Redevelopment of Twin Towns Services Club

At Lot 1 DP 777183
Wharf Street, Tweed Heads

Architectural Design Statement

Environmental Assessment Submission
January 2009

PROJECT: TWIN TOWNS MAJOR PROJECT APPLICATION
DRAWING TITLE: PROPOSED ENTRY PATH SECTION
CLIENT: TWIN TOWNS SERVICES CLUB

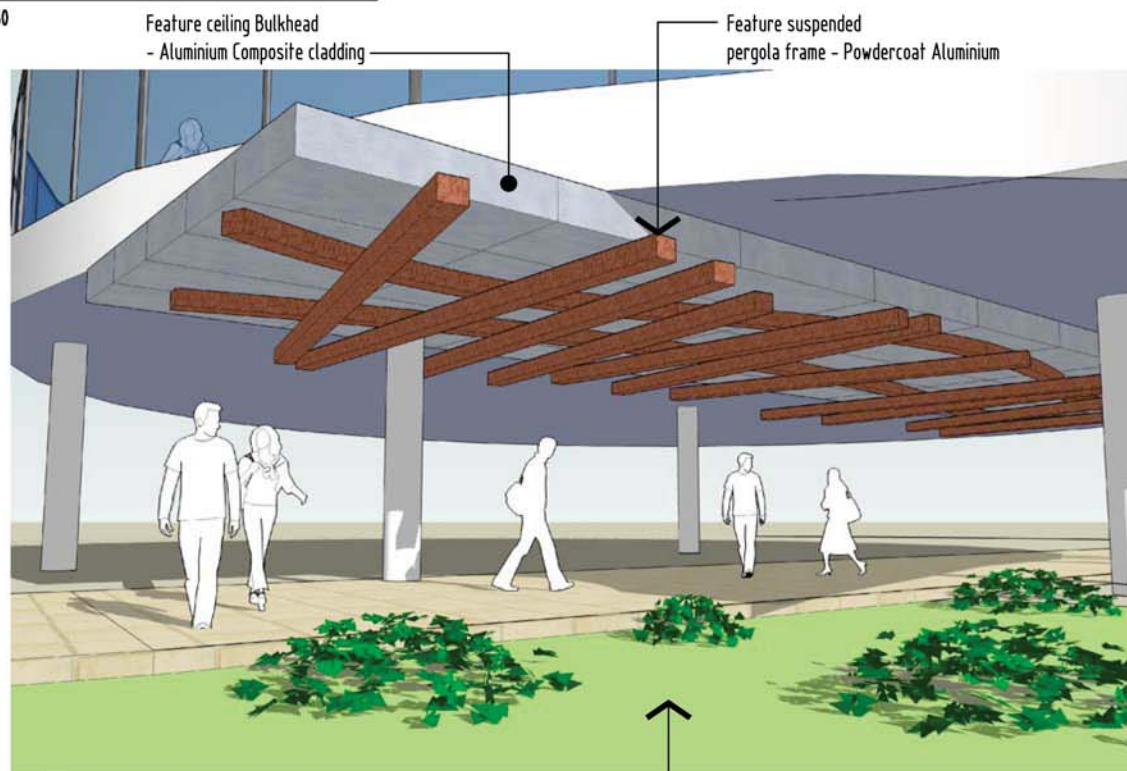
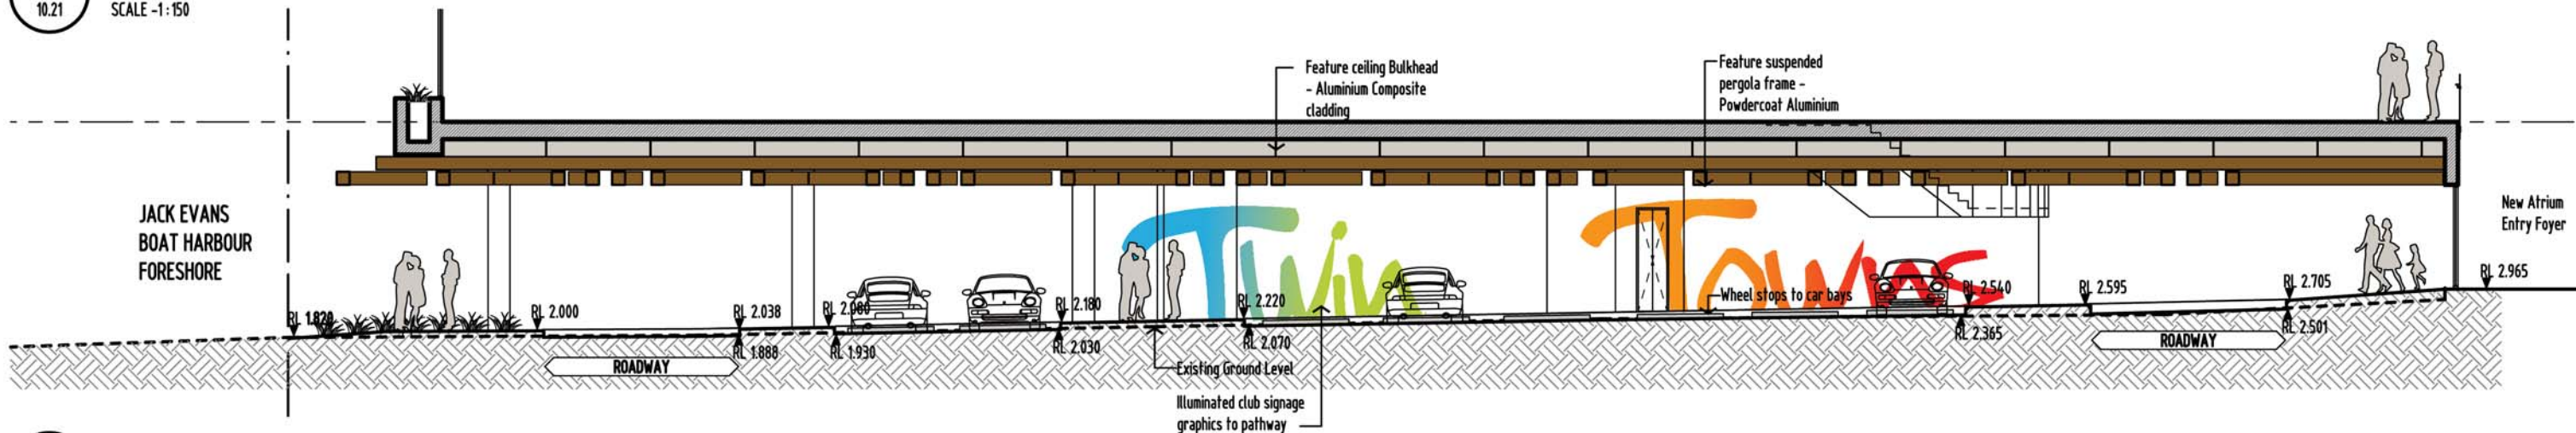
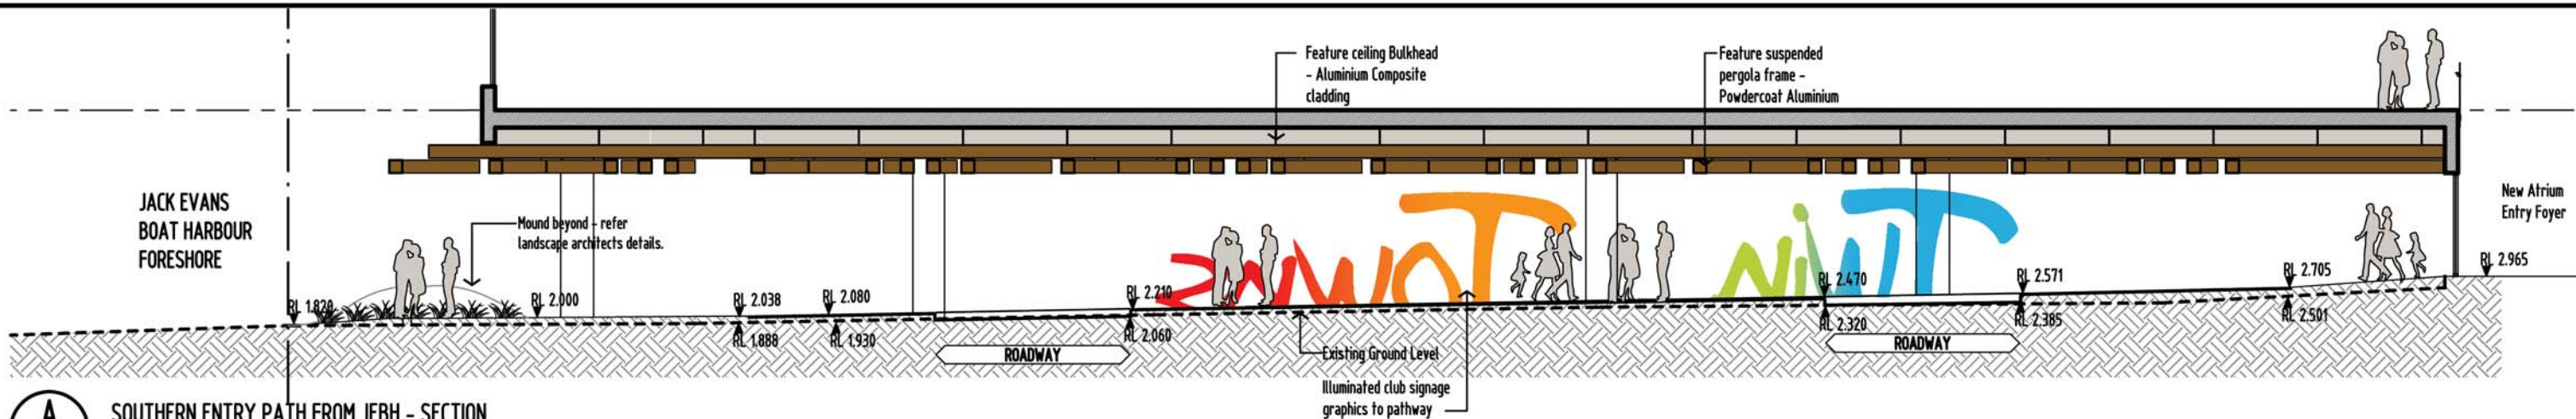
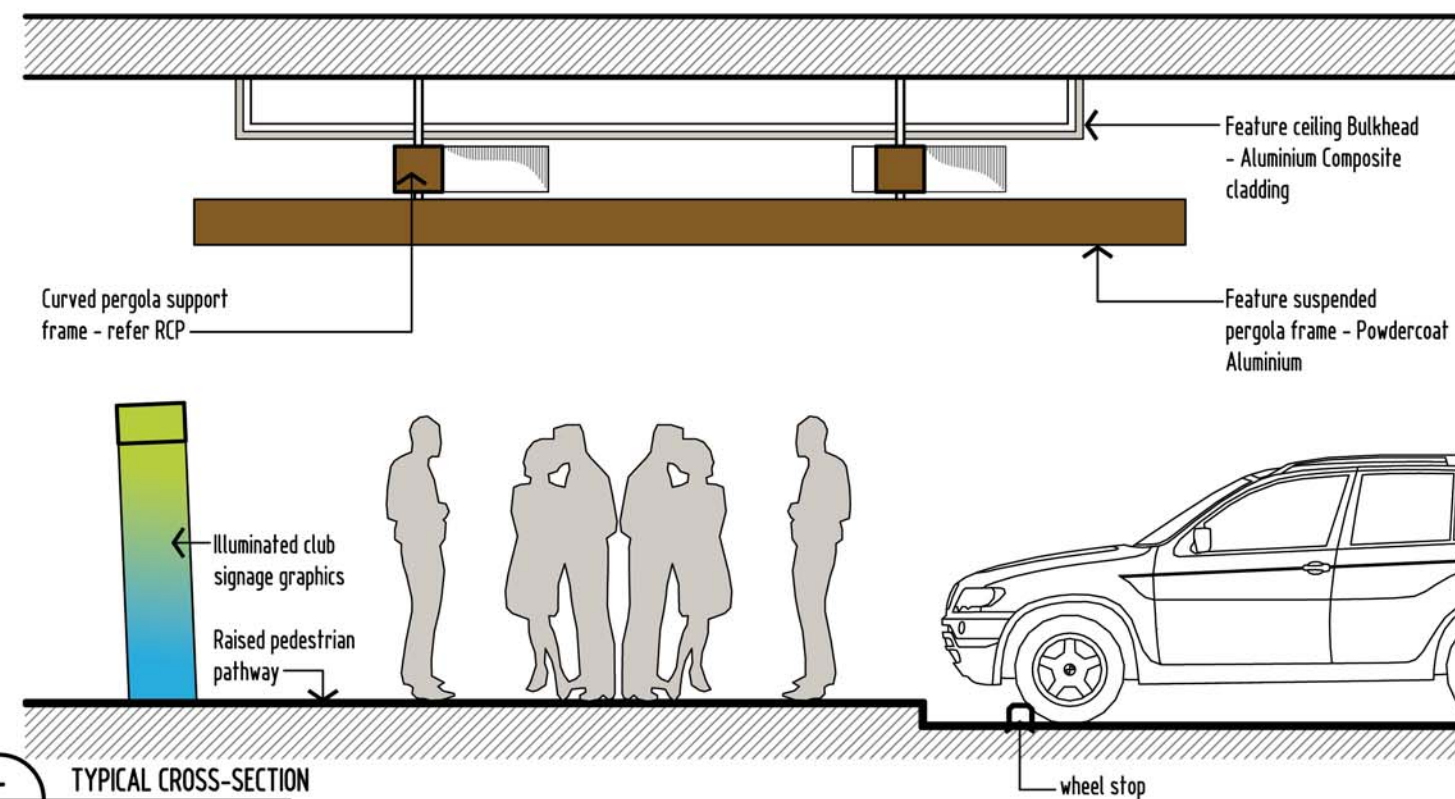
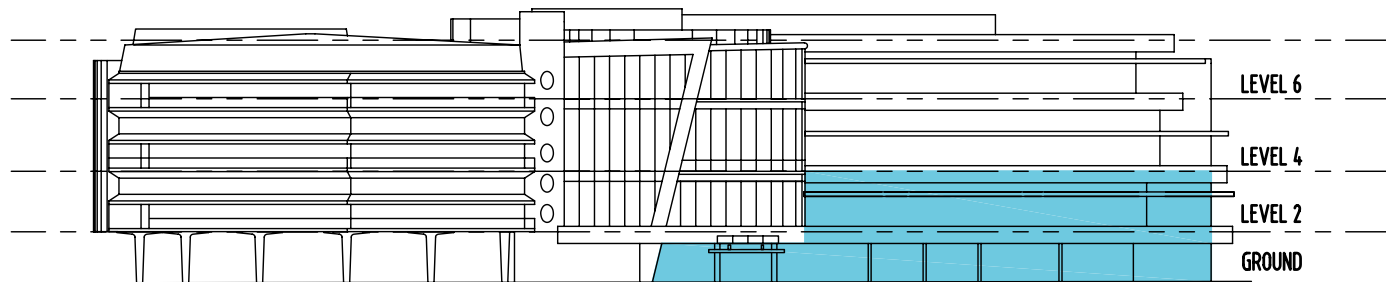
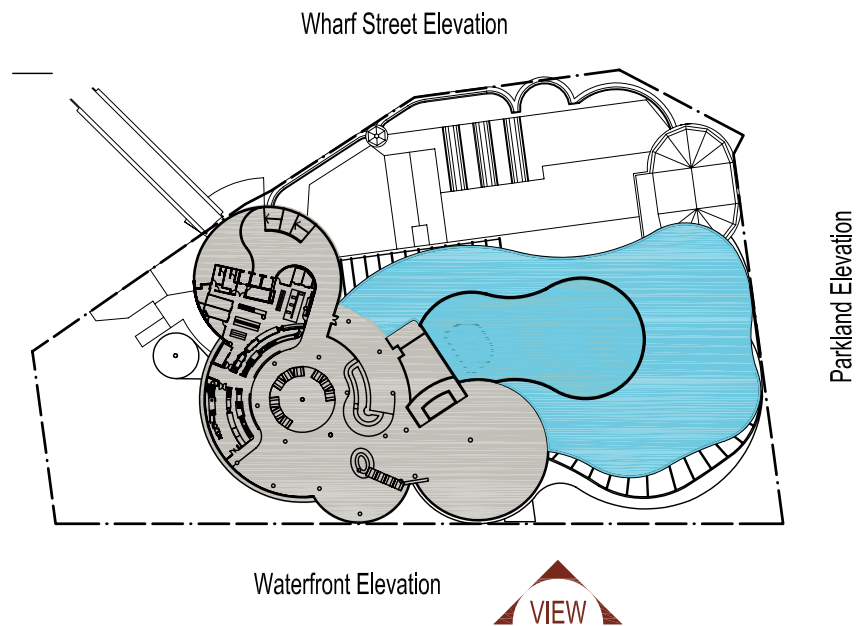
10. Safe pedestrian access to the club from the JEBH and from Wharf Street is essential to the overall design.

Pedestrian circulation from Wharf Street & JEBH to the Club entry foyer has been redesigned to provide safe access. Raised pedestrian accessway, traffic calming devices & signage and feature ceiling treatment including architectural lighting all combine to improve legibility of access to the club in a safe manner.

FINISHES SCHEDULE

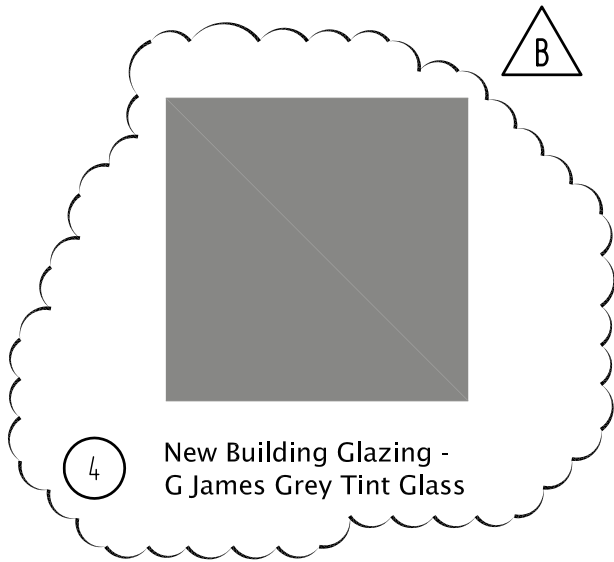
- 14. Better resolution of façade design for the entire building is required. The current proposal is not clear.**

The material palette of the façade treatment has been developed to complement the existing buildings concrete, masonry, aluminium & glazed facades and as further portions of the club are redeveloped this would form the dominant architectural palette (refer BGD Drawing DA1 20-04).
